Application No: FP/88/26/HH  
Site Address: 20 Fittleworth Drive Felpham PO22 6QE  
Description of works: Single storey rear extension and alterations to fenestration.

OWPC85632

26/028
PROJECT NUMBER:
PL1
DRAWING NUMBER:
A
REVISION:

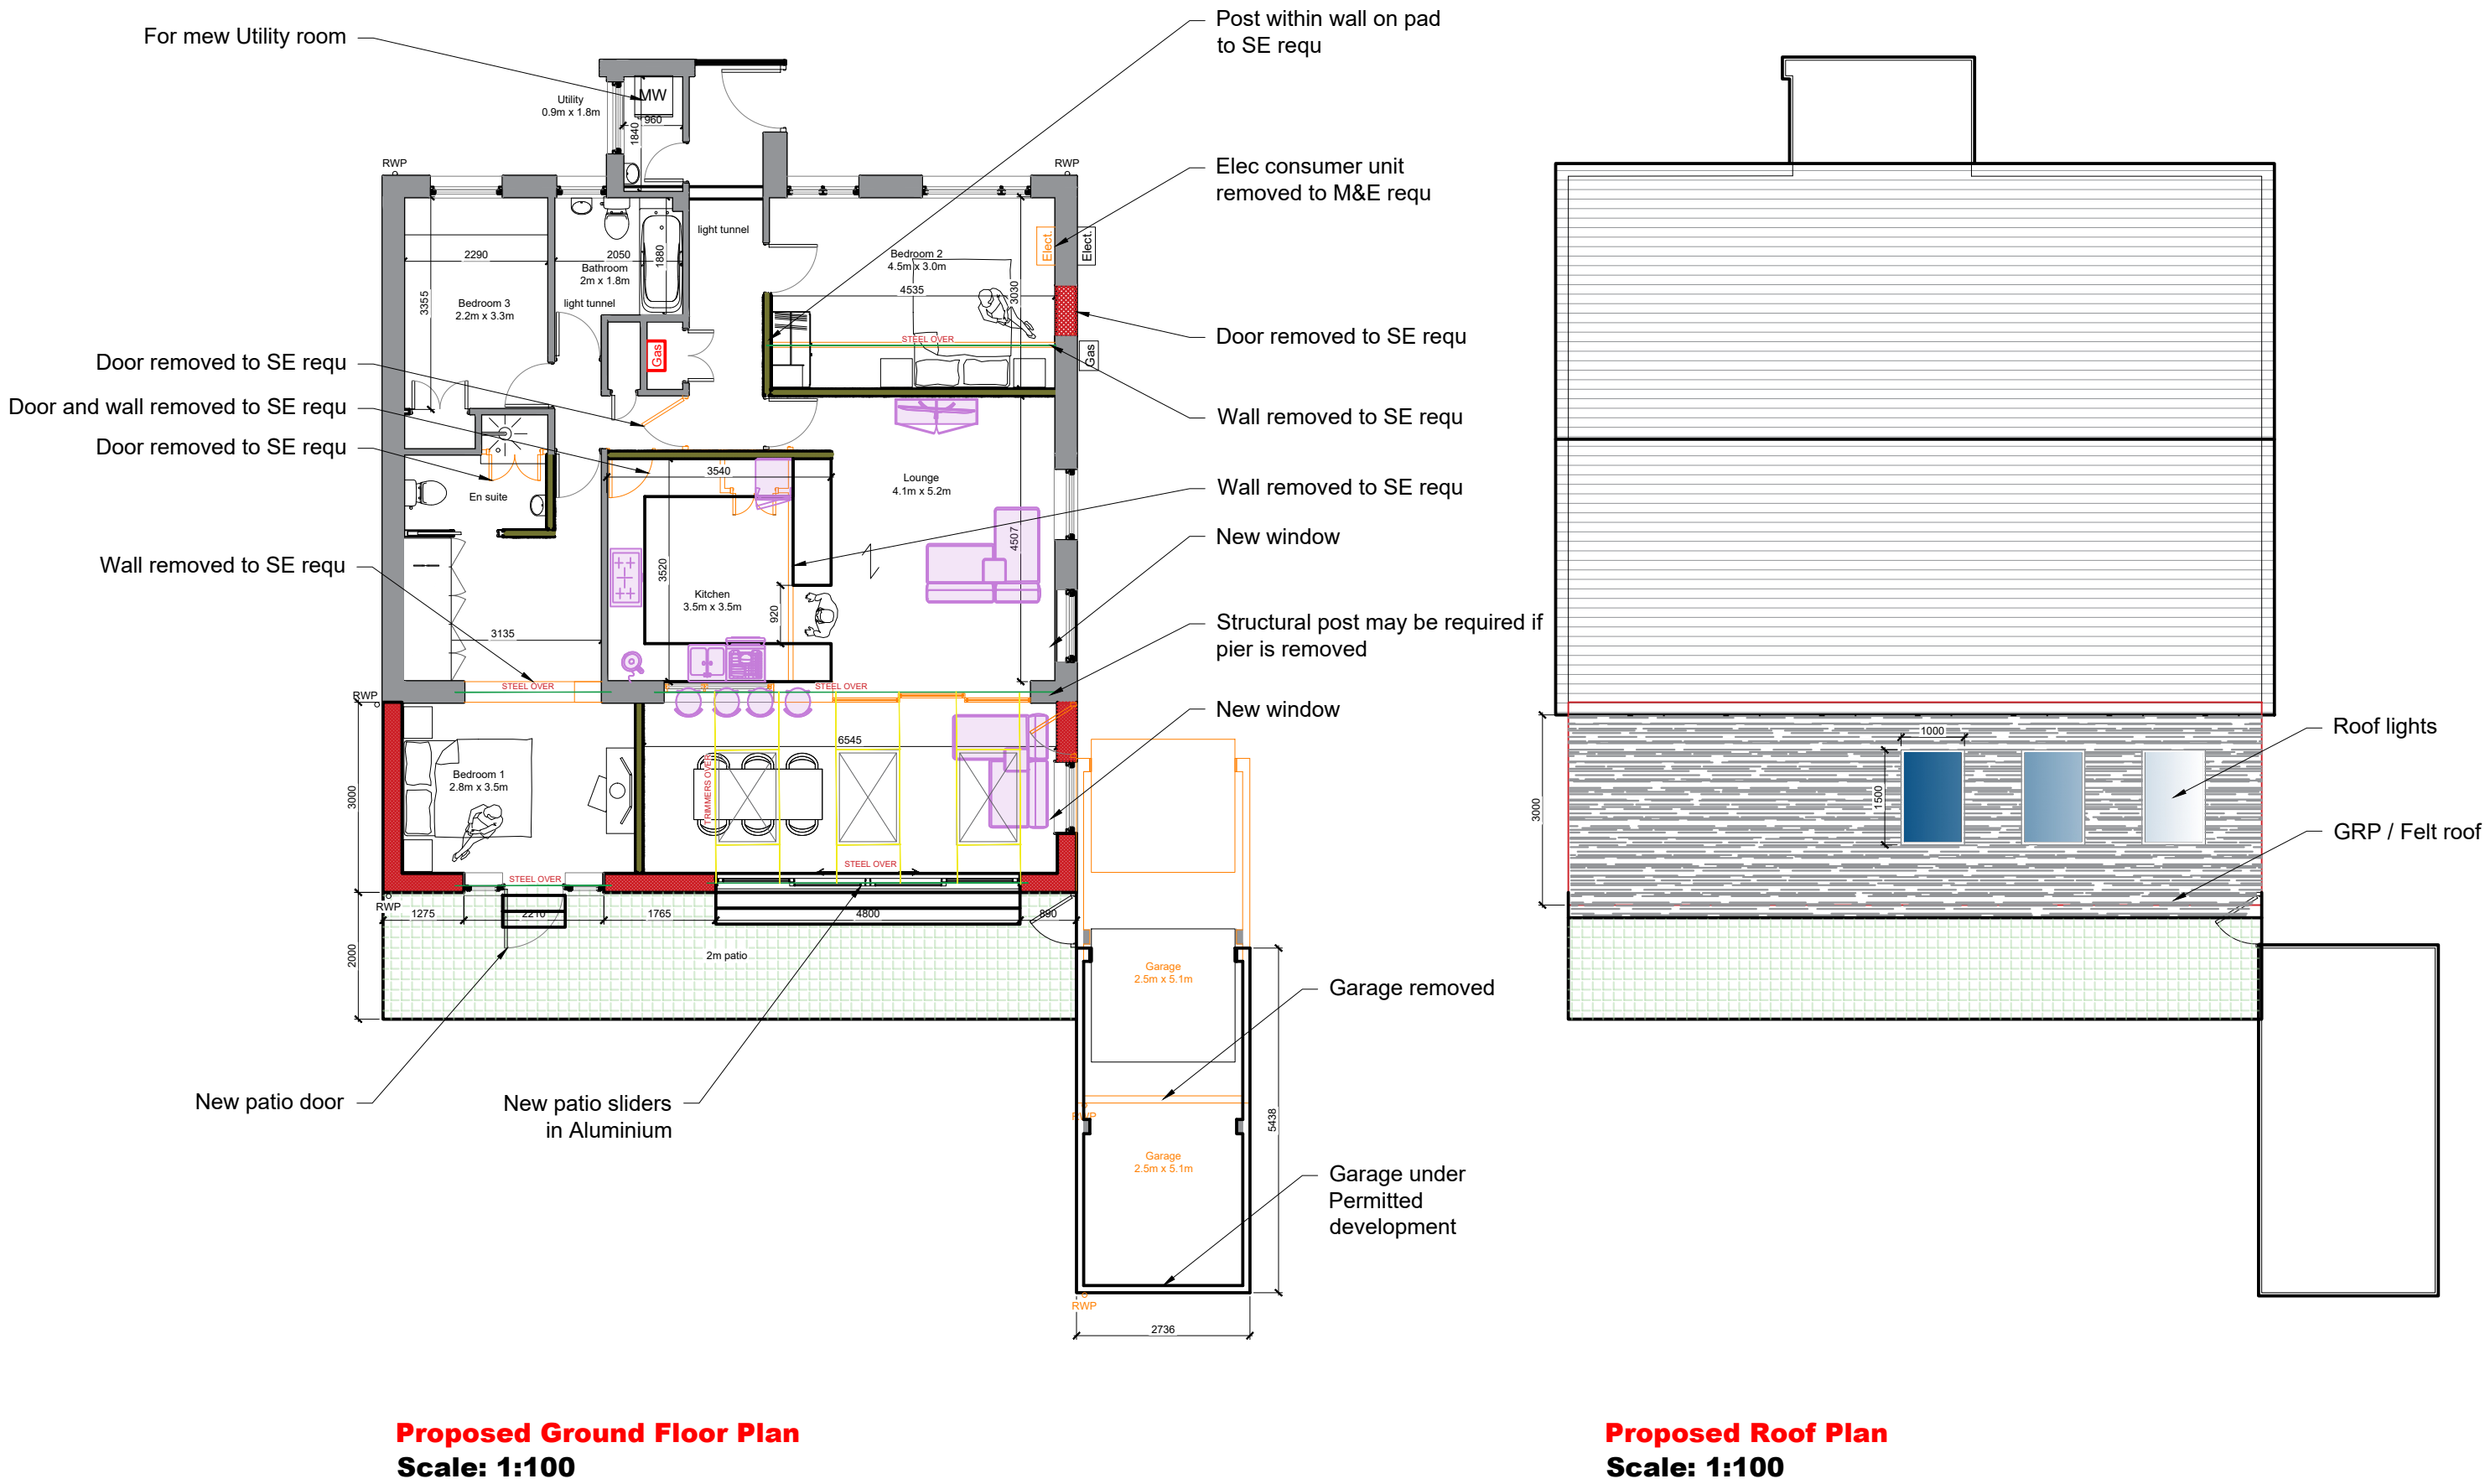
Felpham Parish Council has no objection to this application.  
Note: West elevation on plans incorrect.
